Application by Thurrock Power Ltd for an Order Granting Development Consent for the Thurrock Flexible Generation Plant Project

Response to Procedural Deadline D

Specialist Archaeological Advice

20/00273/DCO Thurrock Flexible Generation Plant, Fort Road, Tilbury

Figure 9

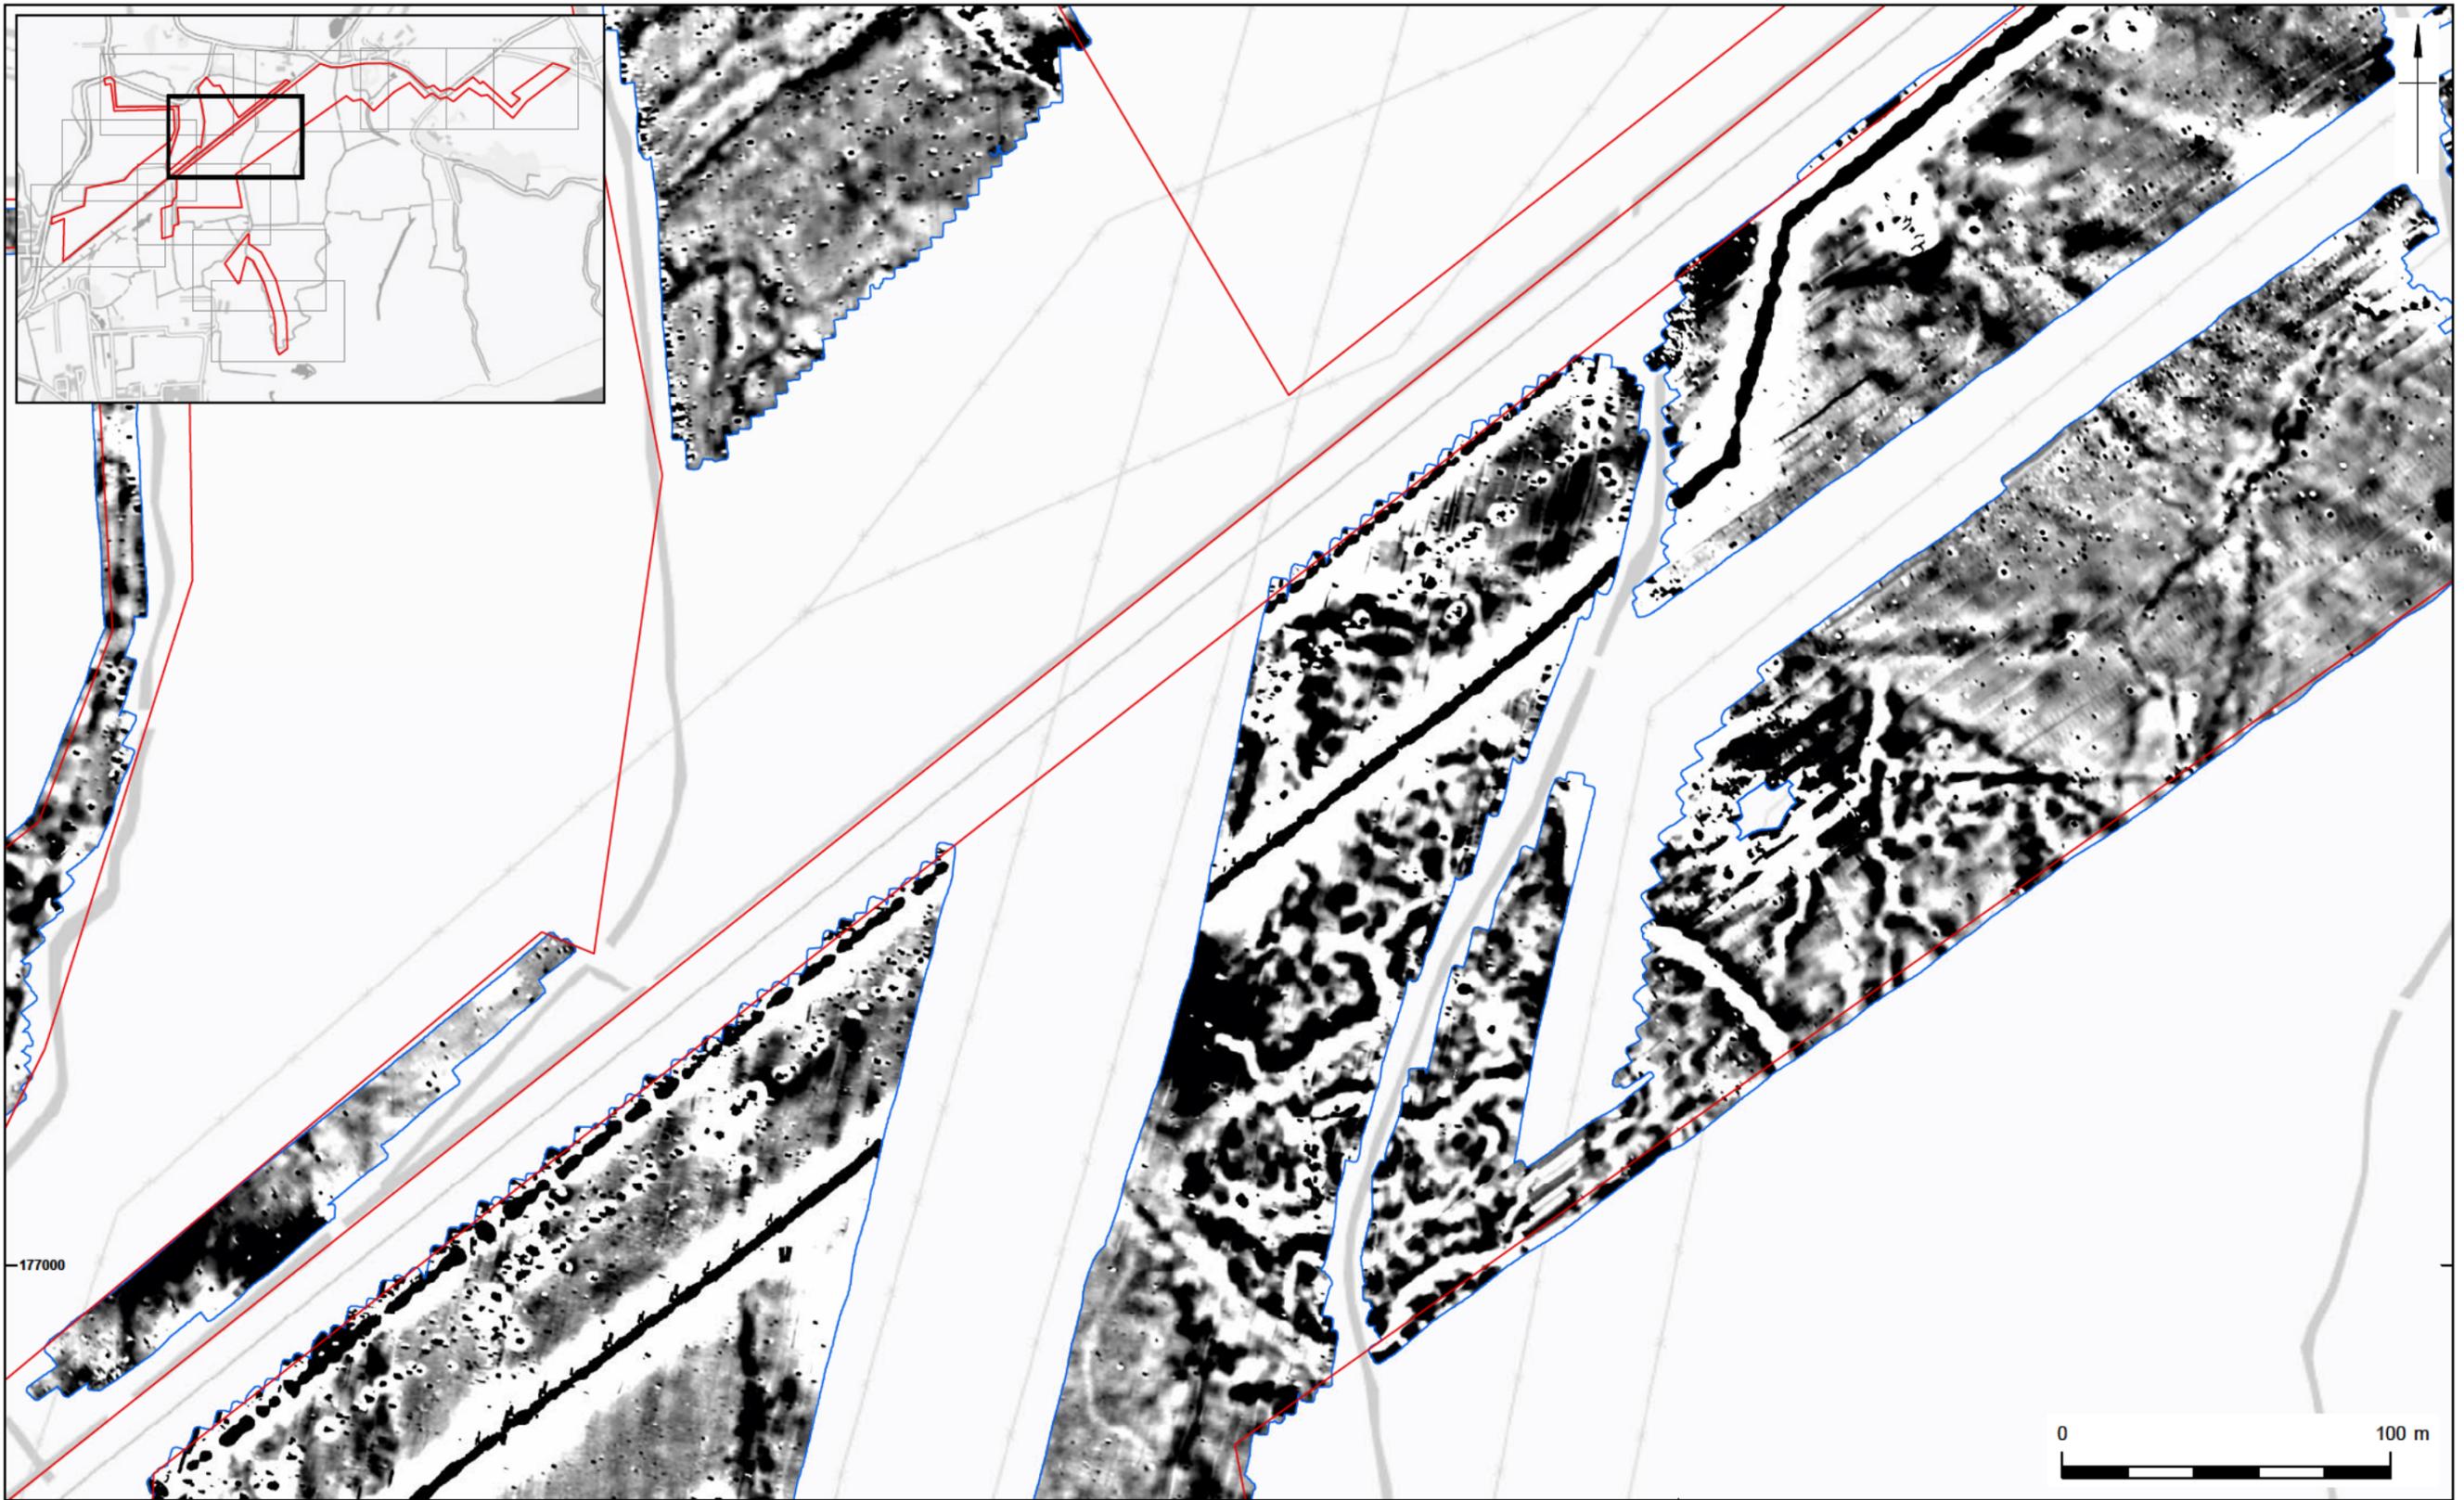
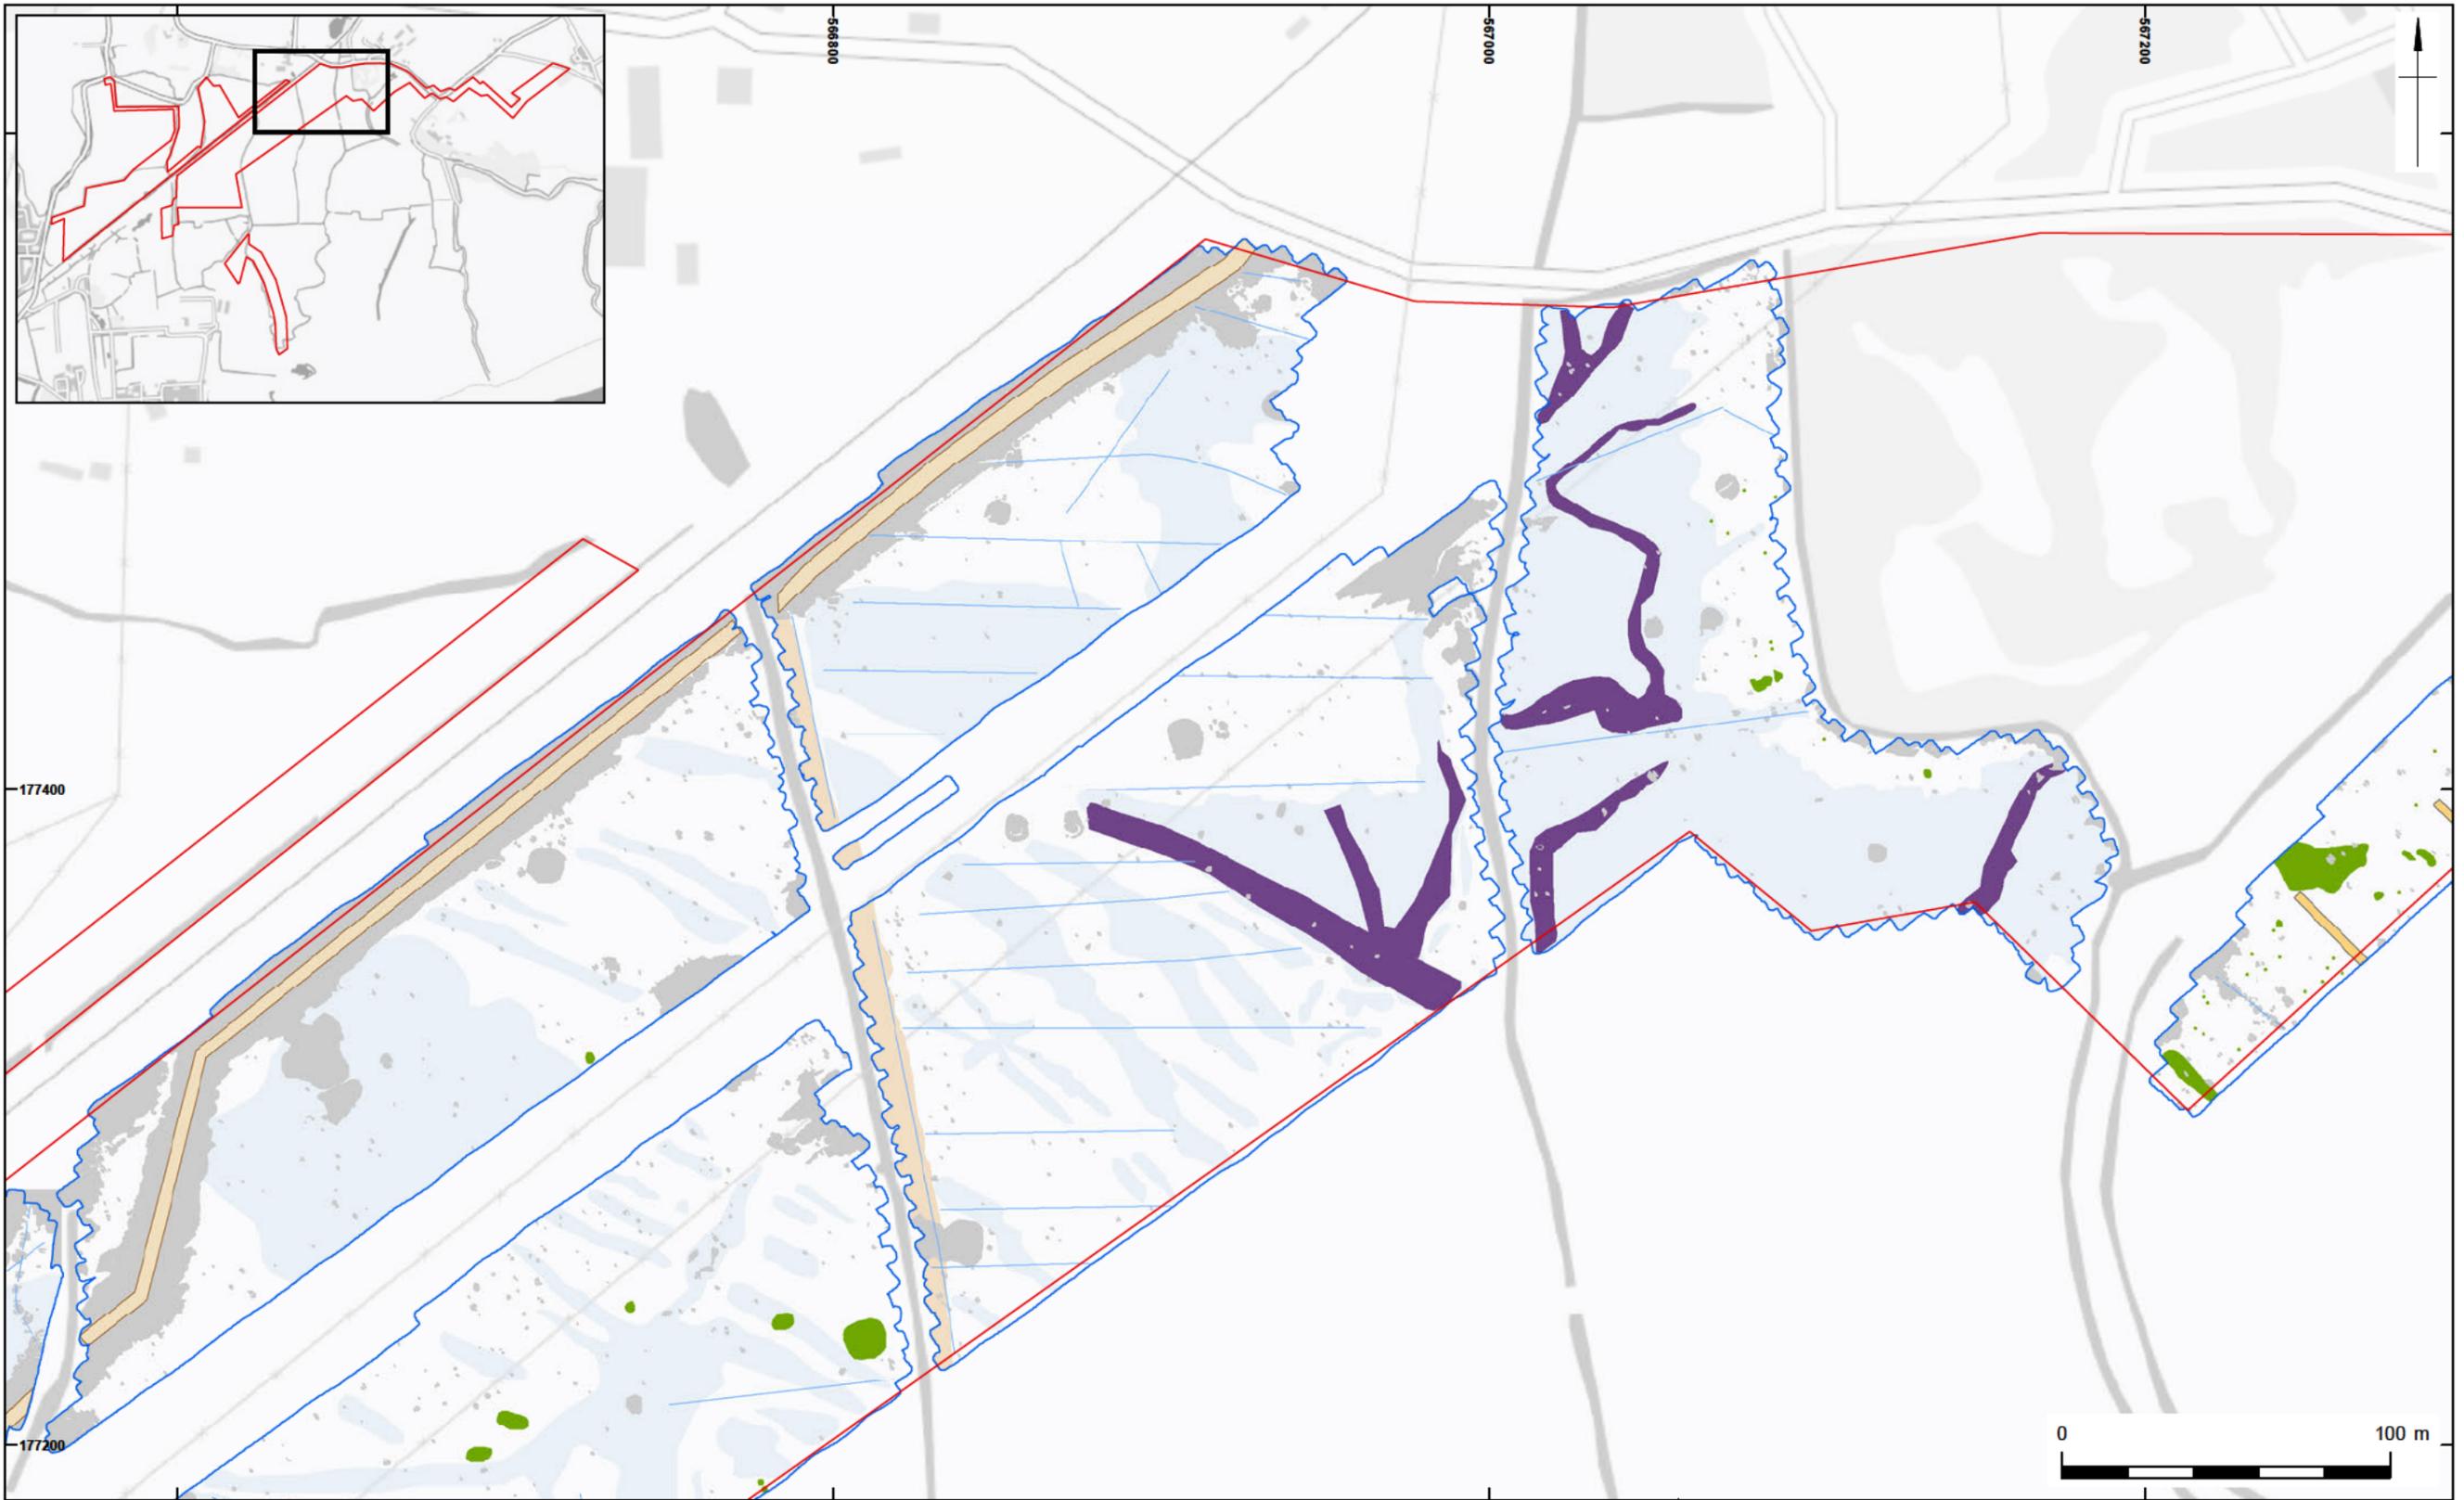
It is pleasing to see that in the documents provided in December that geophysical surveys have been undertaken on the majority of the development area. This provides basic data which can be built on to facilitate an understanding of the historic environment so that the inspector can make an informed decision on the impact of the development. It is disappointing that the applicant does not have the detailed results of the geophysics as the present document provides little detail on the results.

These results also need to be ground truthed to have an understanding as to what the features represent. Large scale developments in the area have shown extensive red hill (saltern) complexes surviving within the grazing marsh area. Similarly, the Lower Thames trial trenching, being undertaken to support their DCO submission has shown an extensive archaeological site of Roman date at the eastern end of this application.
